File No: R/2014/14A, R/2014/40 and R/2014/41
Our Ref: 2014/548668

RE: Barangaroo South: SSD 6513 (Building R1), SSD 6623 (Building R7) and SSD 6425 (Building C2/C6)

The City has reviewed State Significant Development Applications SSD 6513, SSD 6623 and SSD 6425 for Buildings R1, R7 and C2/C6 respectively.

# ground floor plan

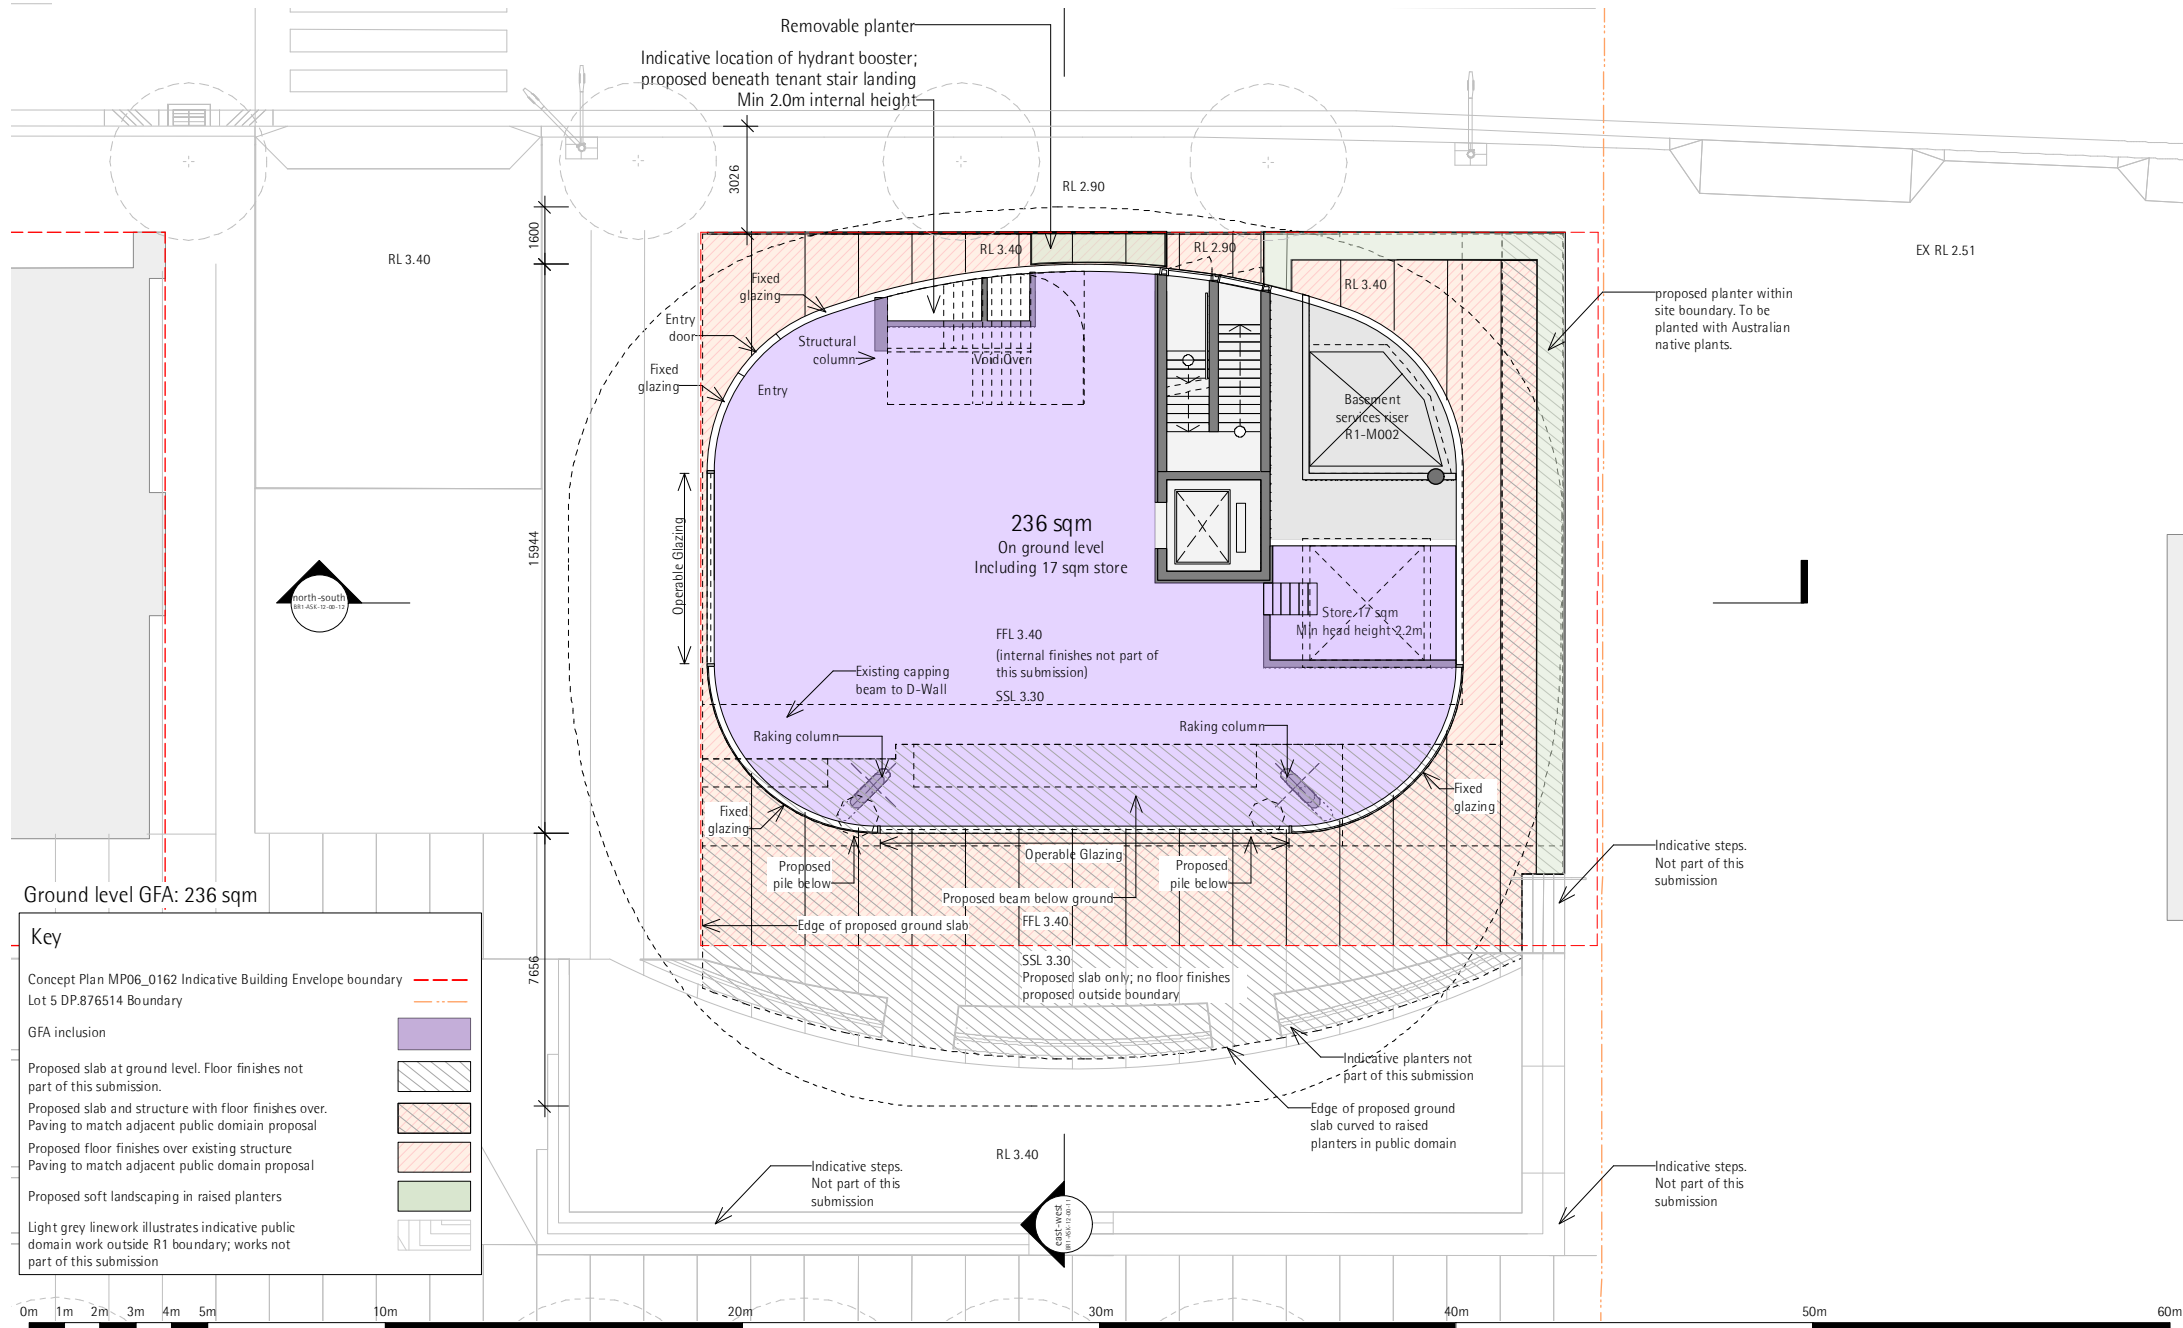
Although building R1 is conceived as an object building, to be experienced in-the-round, the ground floor uses and elevations to Lime Street and the south indicate largely blank, inactivated facades.

The long concrete planter to the south creates a wall at pedestrian level, and a terrace that effectively seems to be dead space - too narrow to serve any function. Consideration should be given to carry through the stairs indicated to the south-west of the building to become a place for people to sit or a broader catchment for pedestrians approaching the building. Such a response may assist in extending the well-activated western front of the building around this corner.

It is accepted that there may be only limited scope to activate the south-east corner of the building because of services, however, consideration should still be given to removing the planter return here. Furthermore, it will be critical to ensure that materials along the Lime Street facade are of very high quality and inherent interest.
